**OXFORDSHIRE COUNTY COUNCIL'S RESPONSE TO CONSULTATION ON THE
FOLLOWING DEVELOPMENT PROPOSAL**

Application no: 13/01056/OUT

Proposal: OUTLINE - Up to 200 residential units, access, amenity space and associated works

Location: South Lodge Fringford Road Caversfield Bicester OX27 8TH

**Existing Junction Arrangement**

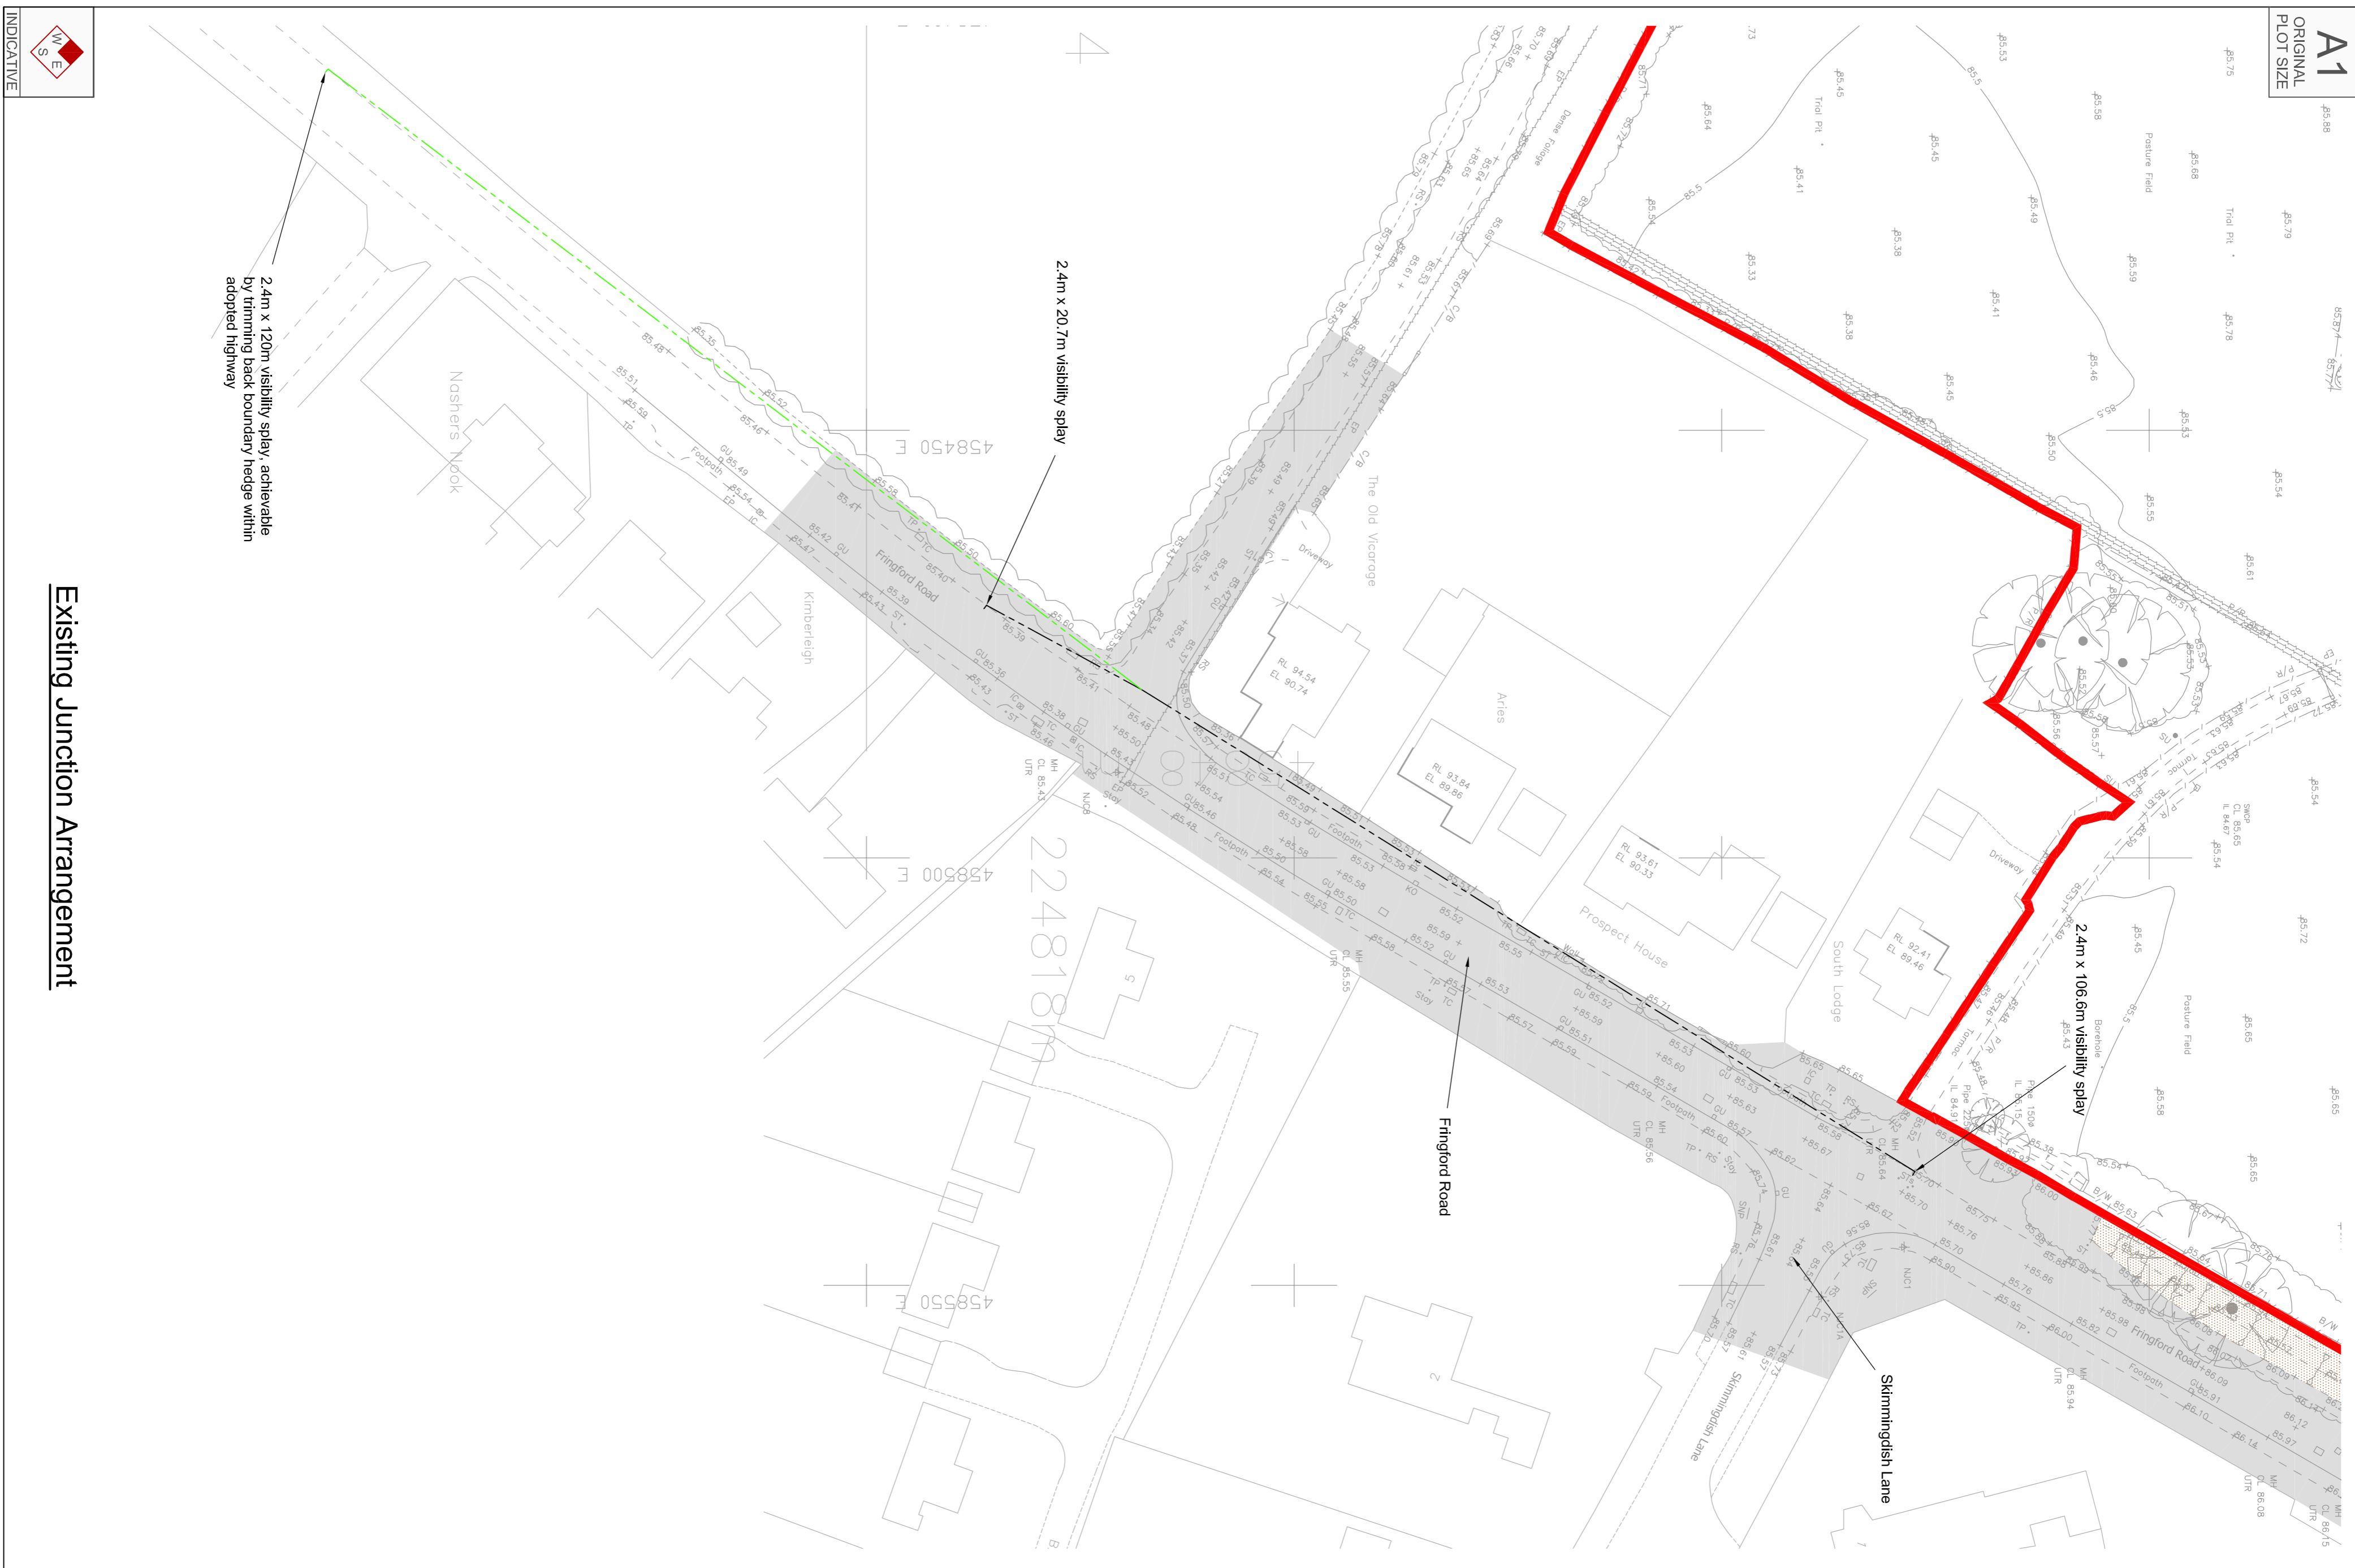
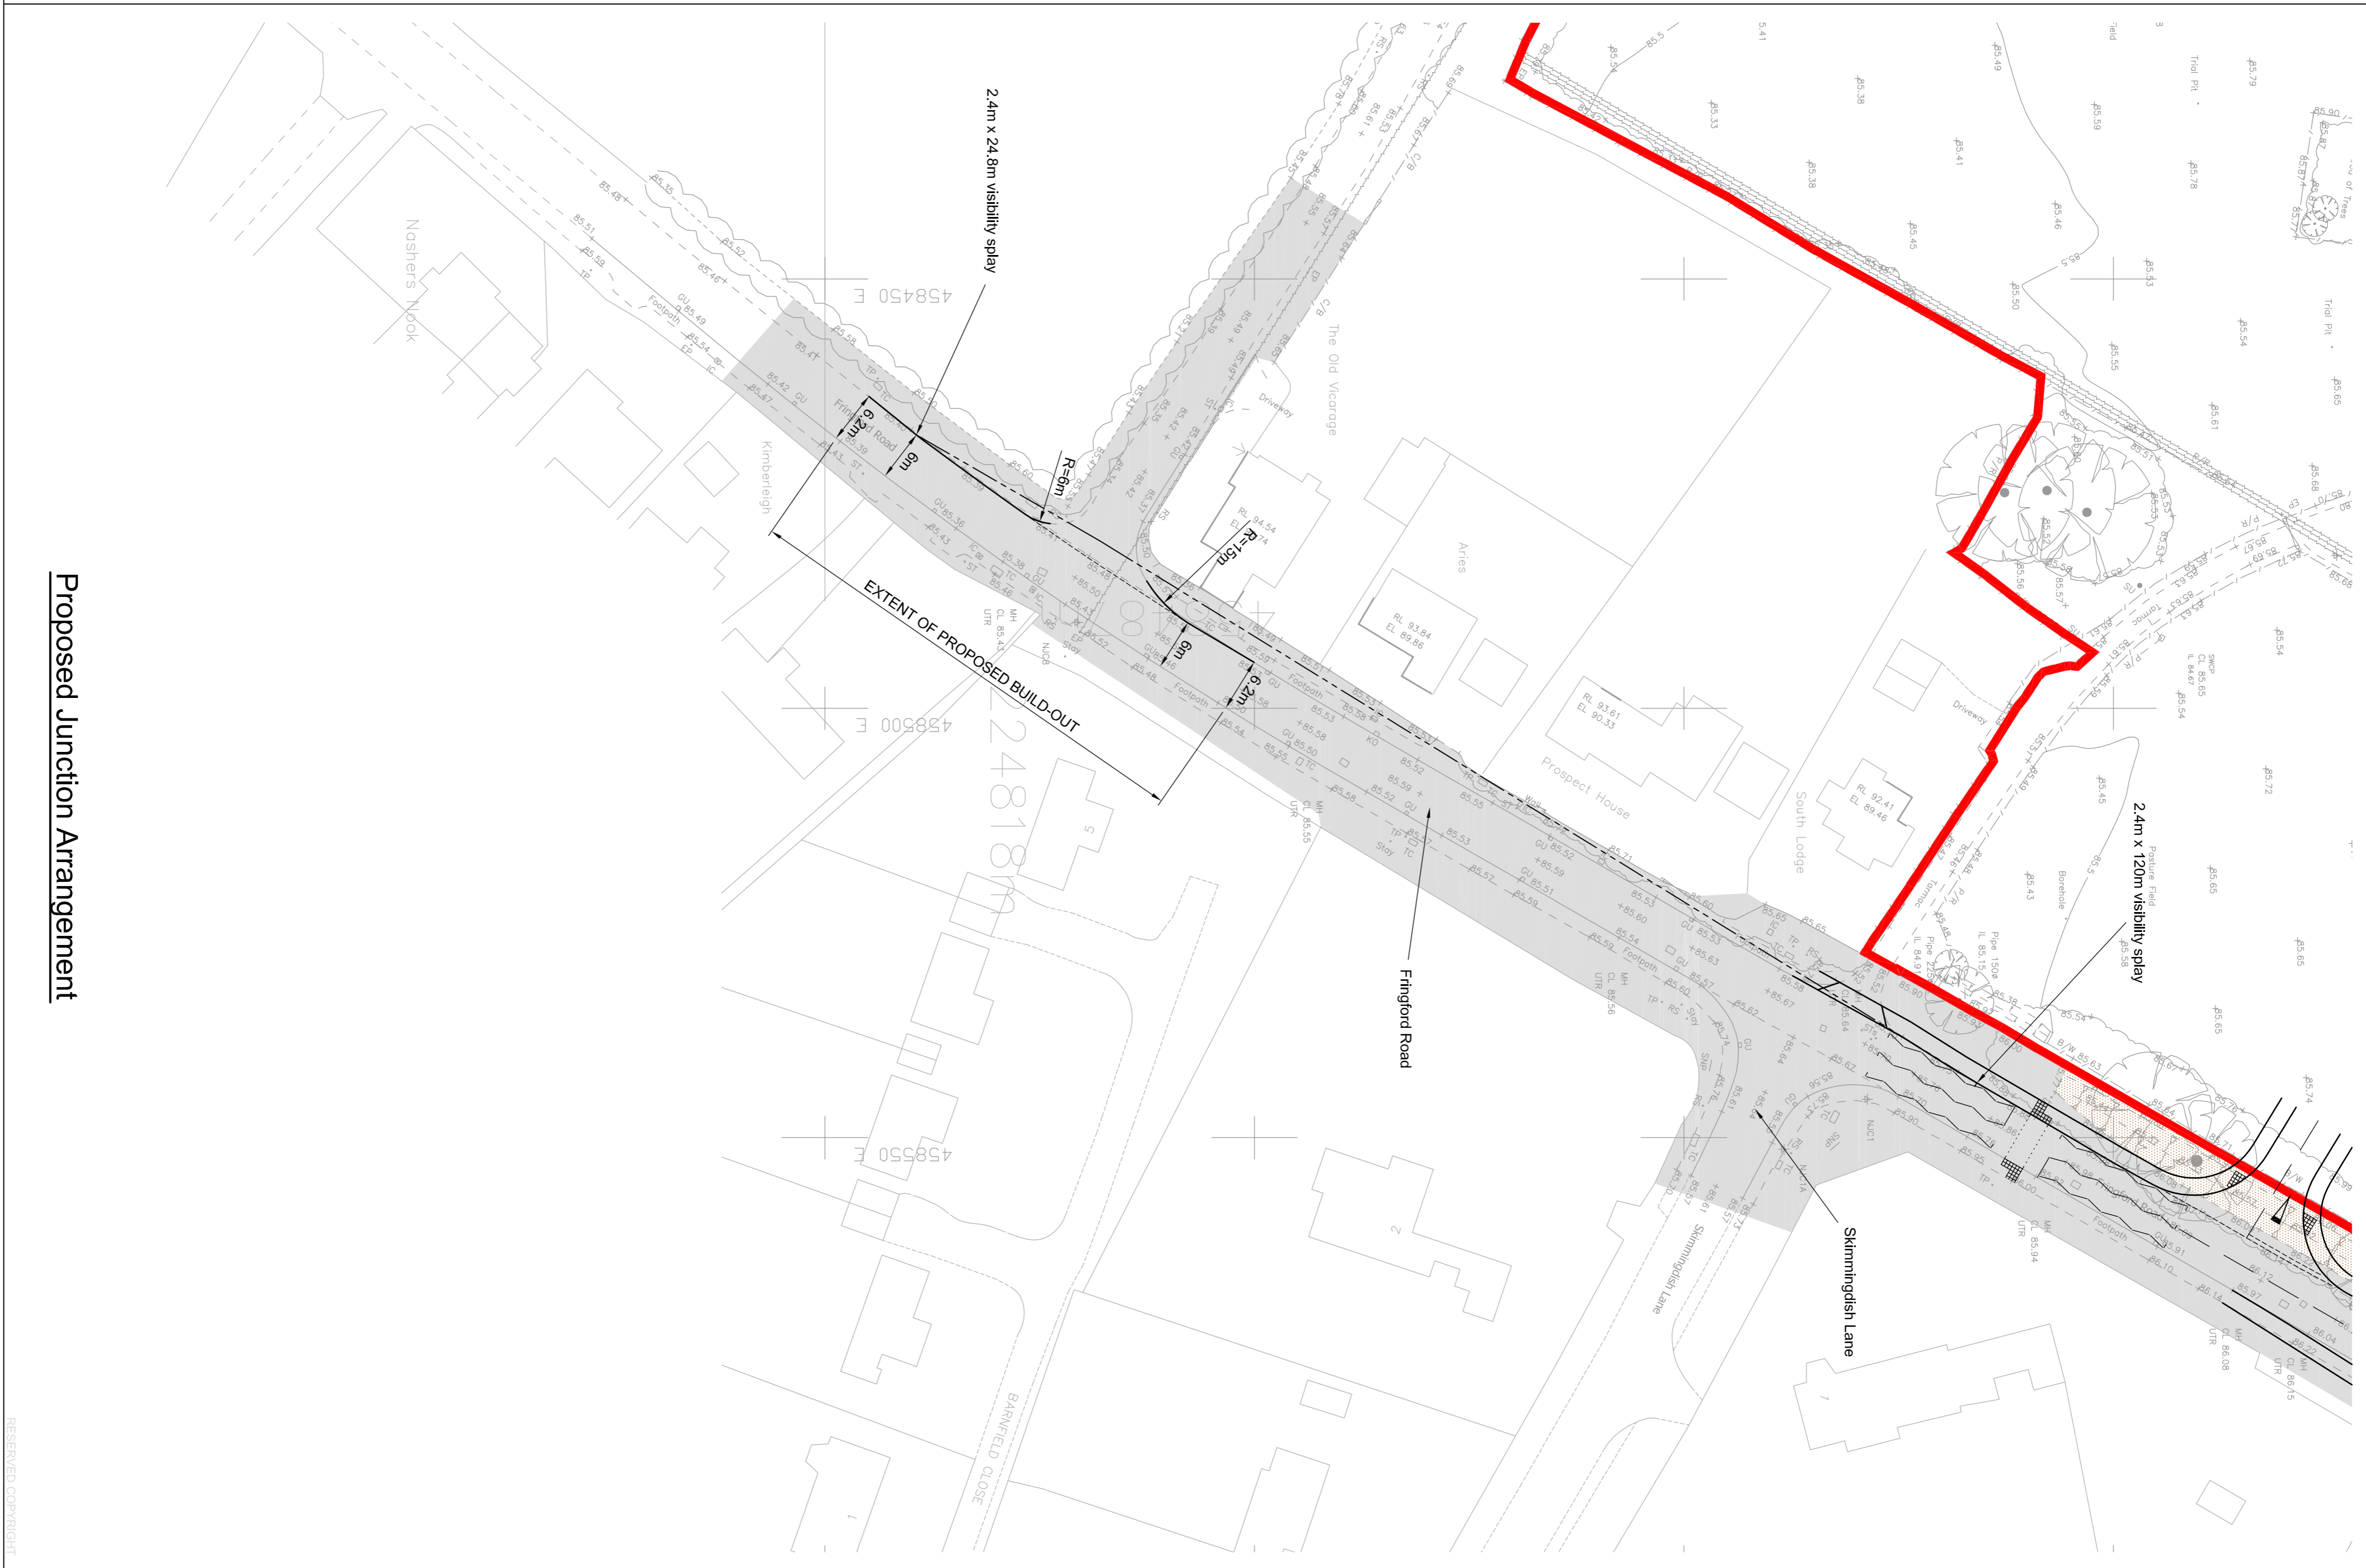
- **Highway safety concerns**, including:
 1. An adequate, safe highway access for the site has not been demonstrated. It is unclear whether the required access vision splay can be achieved within land owned or controlled by the applicant.

The application proposes a new vehicular access onto Fringford Road. The detail of this proposed access, including visibility splays, has not been submitted for consideration and approval. Vision splays of 2.4m x 120m will be required, provided that the 85th percentile speed of traffic in the vicinity is 40mph in line with the local speed limit. Such a vision splay would extend past the applicant's red-line application boundary, and would likely necessitate the removal of third party trees and vegetation to the north of the site. It has not been demonstrated that a safe, adequate access to the public highway can be achieved. **(Concern – highway safety)**

I note from site visit that the visibility from the unnamed road to the south onto Fringford Road is substandard. Given that the proposal is likely to intensify vehicular use of the unnamed road, this is a concern. **(Concern – visibility at unnamed road/ Fringford Road junction)**
